From: [REDACTED]
Sent: 29 August 2023 17:48
To: Planning
Subject: FAO: Emily Pickup - Planning Application No: 3/2023/0627

Following [REDACTED] 95 King Street, Whalley, on the 22nd August 2023 I would like to make a few comments / concerns.

Address of Development: 95,King Street, Whalley,BB7 9SW

6842-002 REV E

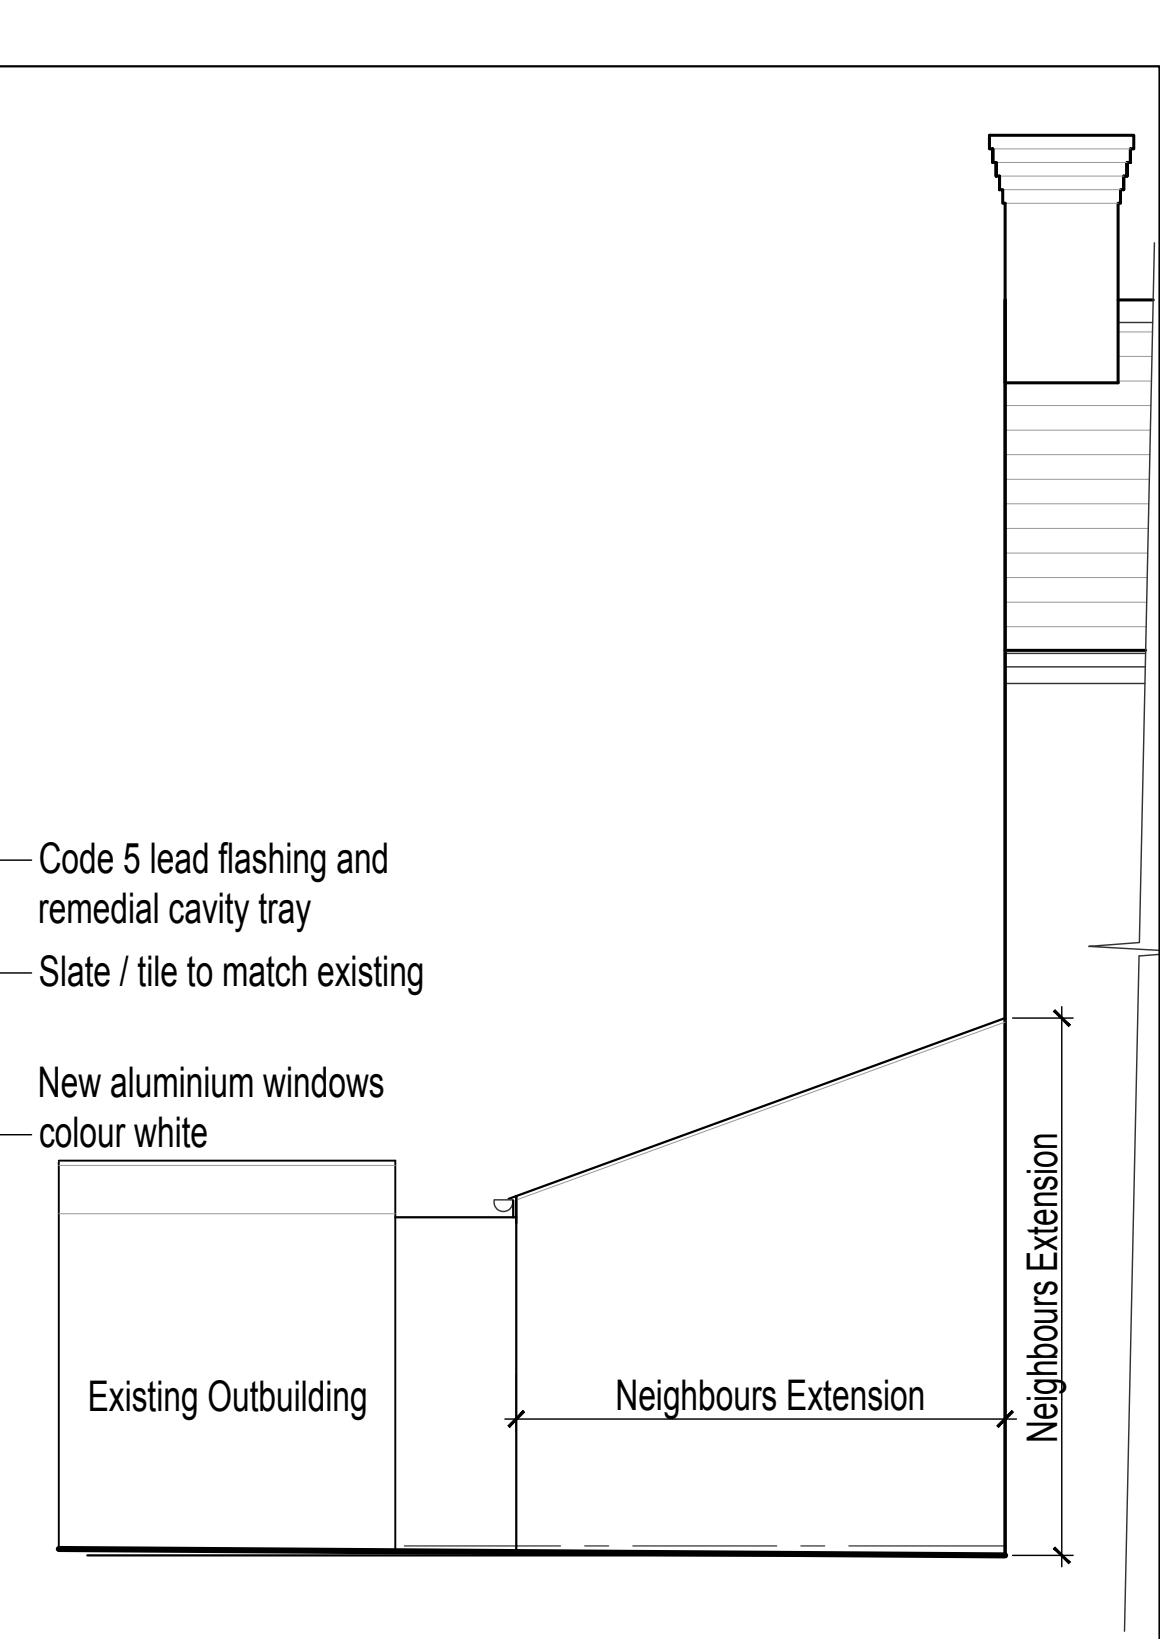
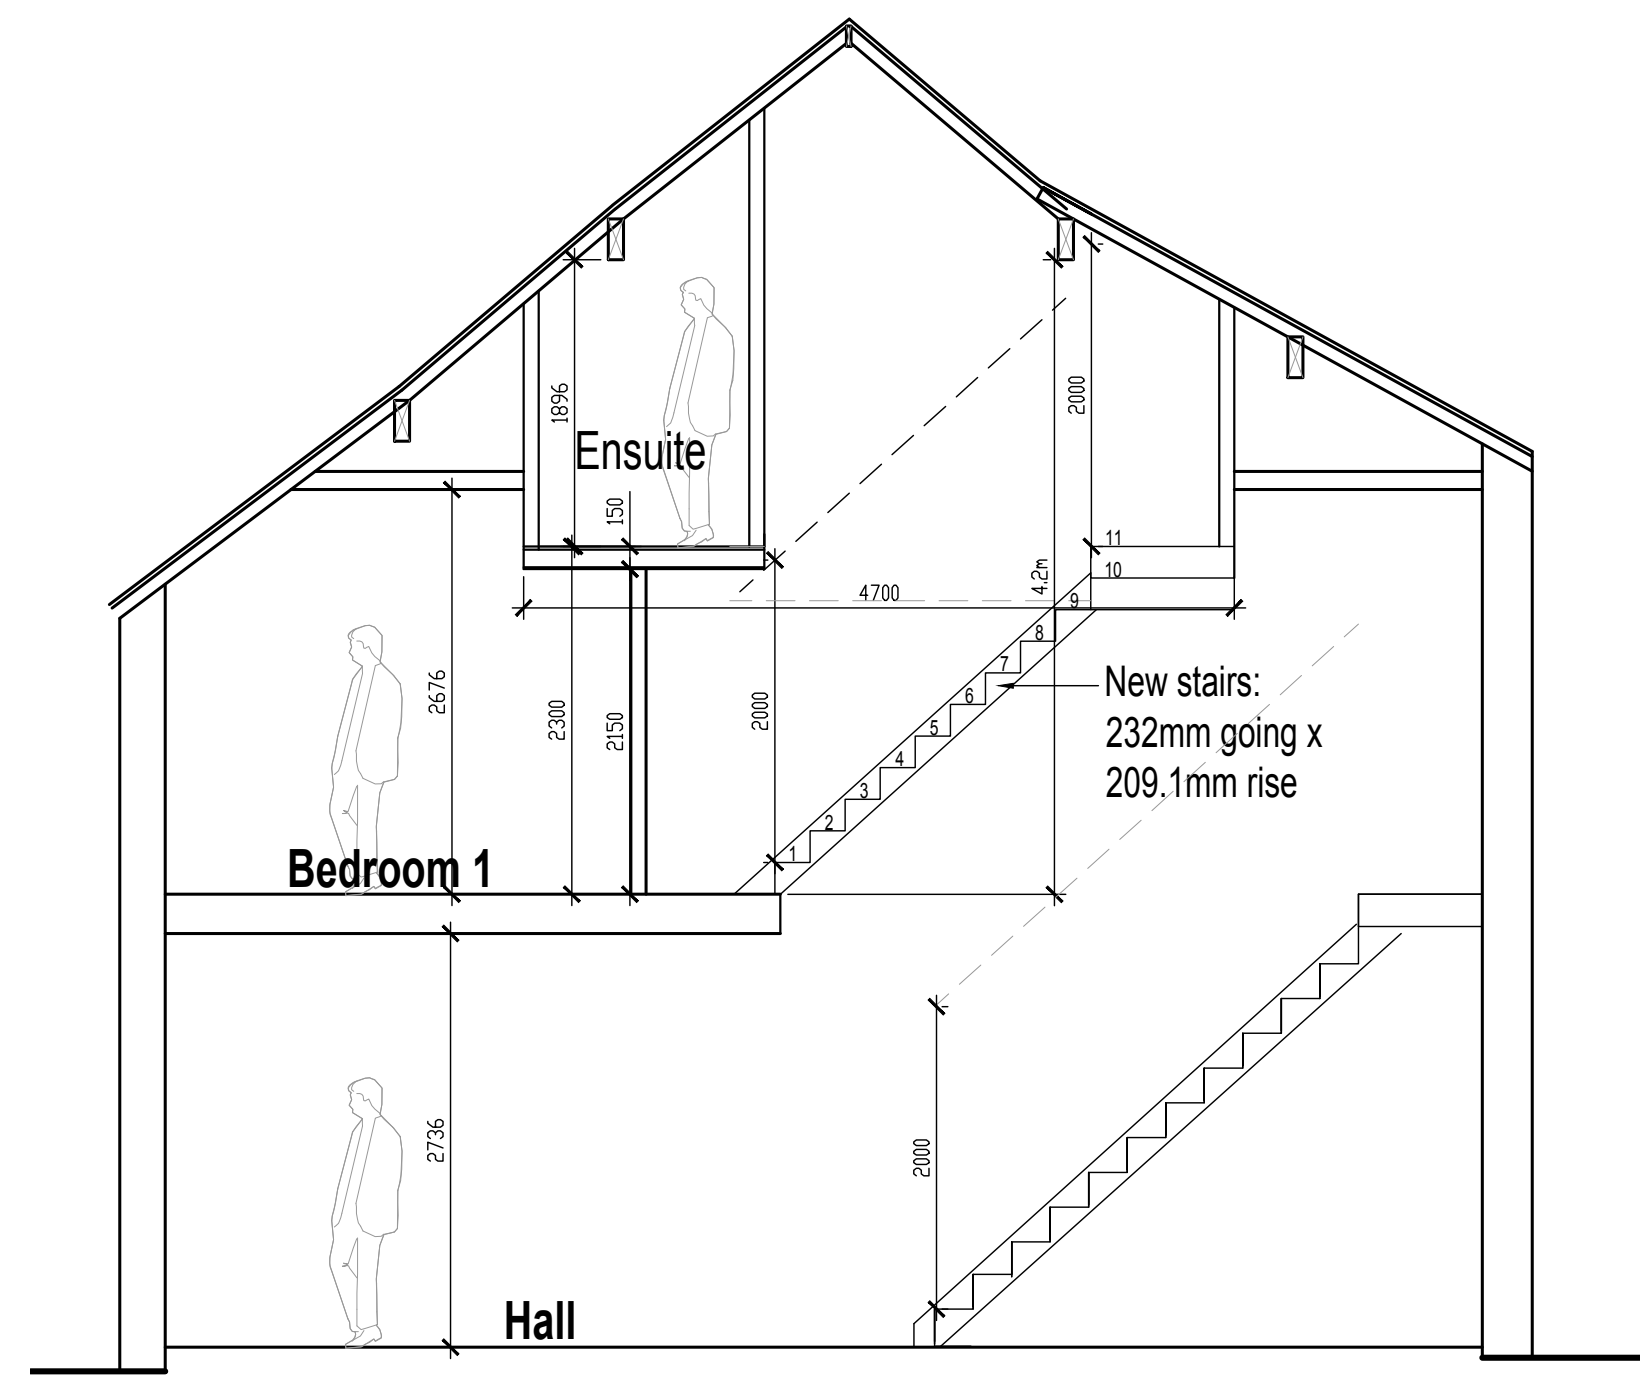
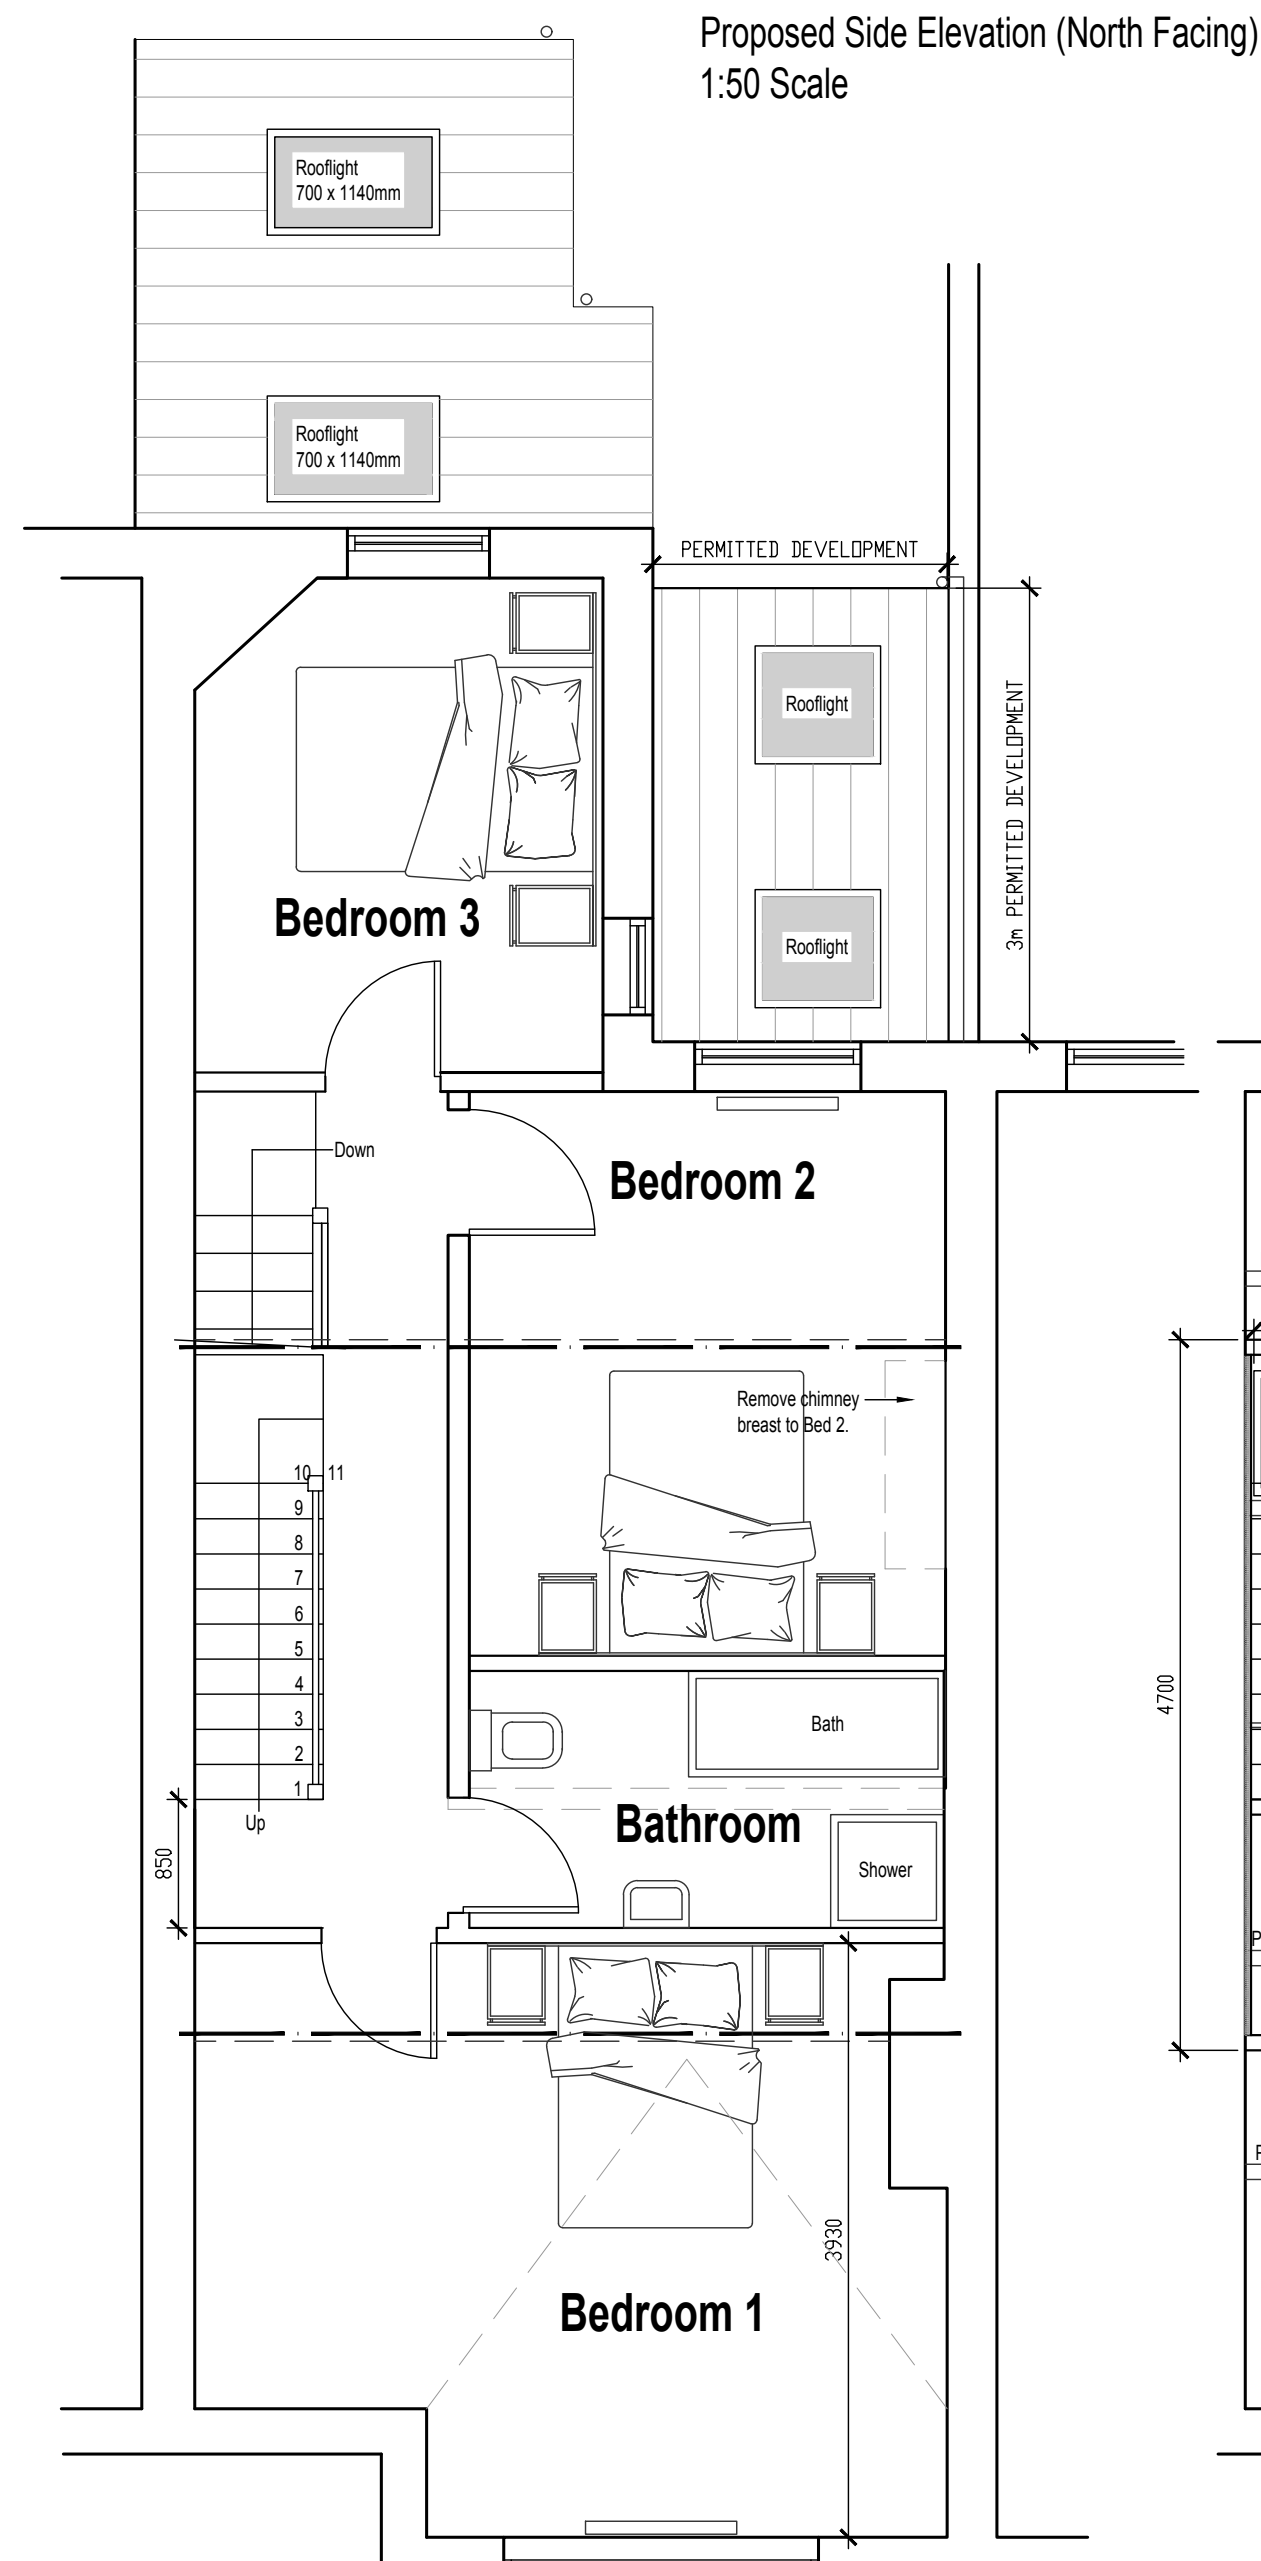
1. The plans are extremely deceptive. The proposed side elevation (North facing) shows the proposed extension roof to meet the existing garden wall which is 1580mm. However, the rear elevation (West facing) shows the proposed extension height of 2400mm. This is not only over 800mm higher than the initial plans which have already been refused by yourselves but will [REDACTED] I can only presume this is an error? Can this be clarified please.

2. I am also concerned about the placement of the new guttering and overflow measures for the kitchen extension. The height of this suggests the guttering will be eye level. Is this correct?

3. The white render is not in keeping with the surrounding houses in this conservation area.
4. The aluminium doors - see above.
5. I have significant concerns about the parking for the property. As it currently stands parking is already an issue as owners / builders of the above named property have blocked the back street for their own parking needs. This is going to become a bigger concern as the 2 bedroom property becomes a 4 bedroom home with no parking facilities. (King Street is 2hrs parking).

6. What materials are being used for the roof?
